**Consultation Response from KC,
Strategic Housing**
2026/91763 Land off Barnsley Road, Denby Dale, Huddersfield,
Erection of 40 residential dwellings and associated works
Date Responded: 07/09/2026
Responding Officer: CH
Responding Ref: SH/26/91763

SITE LAYOUT PLAN - 2530-SI-02F
BARNSLEY ROAD, DENBY DALE
NEWETT HOMES
SCALE:1:500@A1 - AUGUST 2025

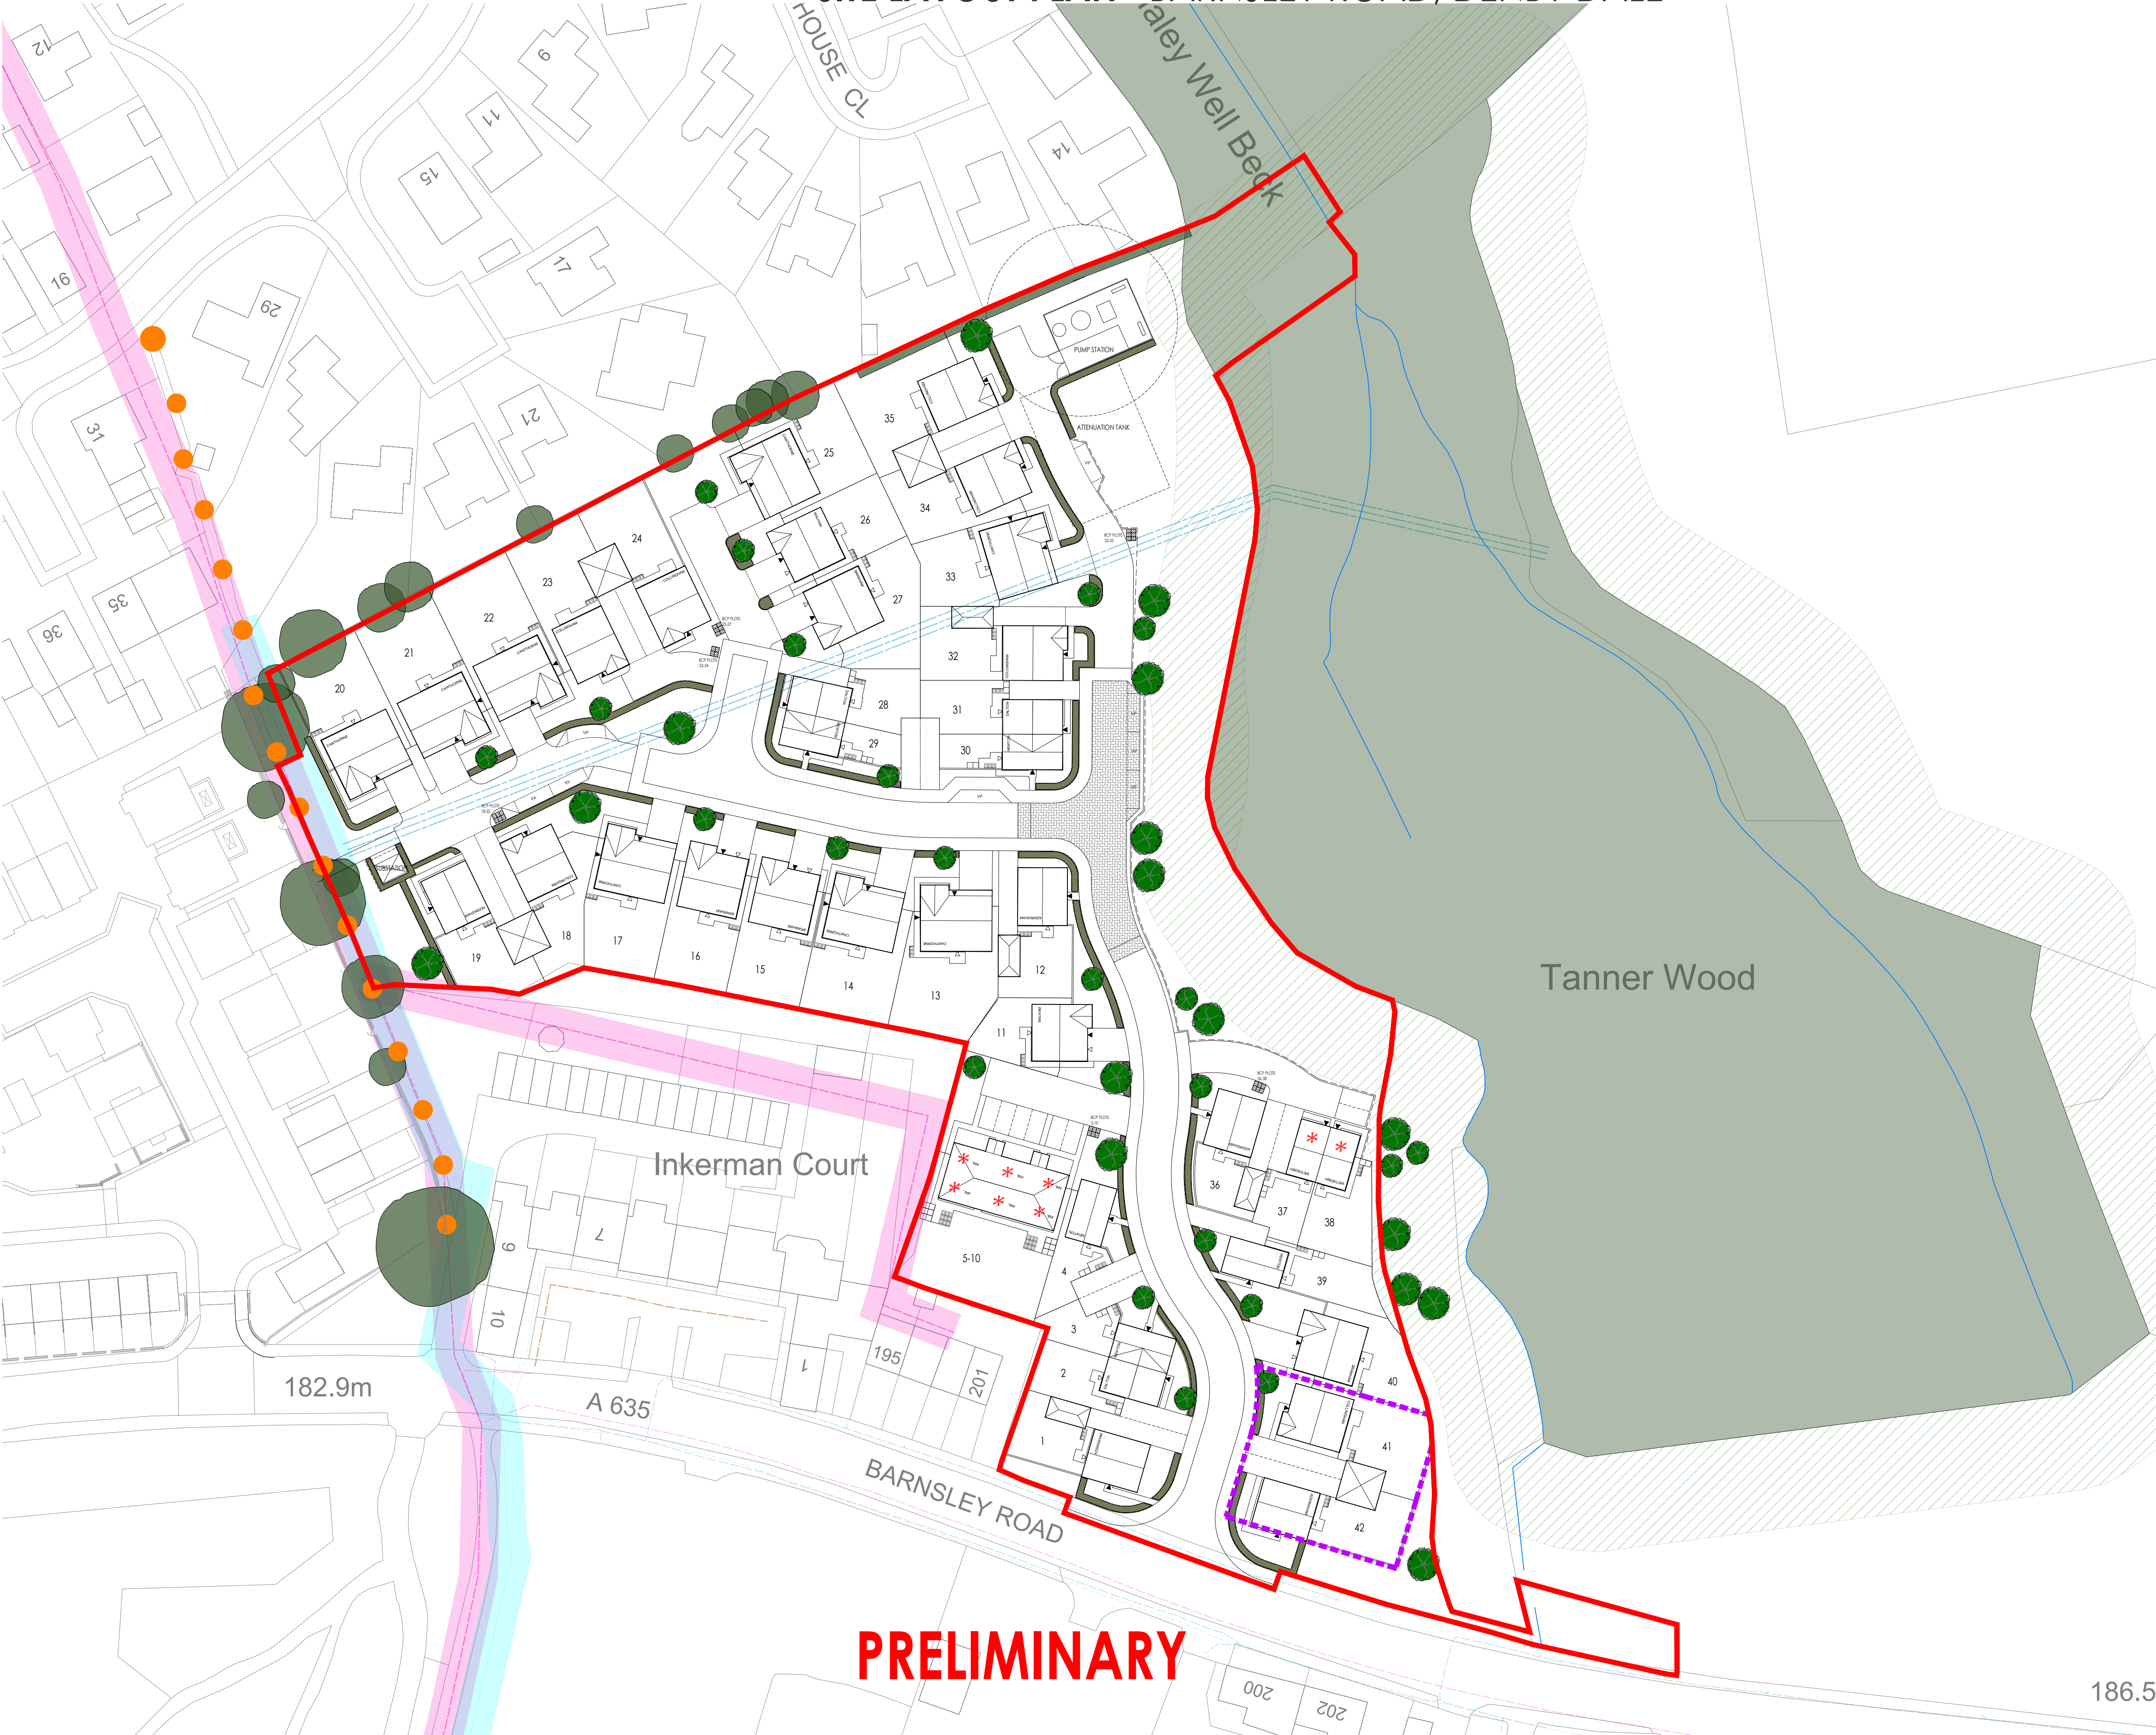
The layout of affordable dwellings should be dispersed throughout the site in smaller clusters, avoiding large groupings of affordable dwellings together that may reinforce social exclusion. Affordable dwellings should be well integrated within the site layout and not located at specific areas at the edges of sites.

The proposed layout shows that the affordable homes are distributed evenly throughout the development and therefore, Strategic Housing does support the current proposal.
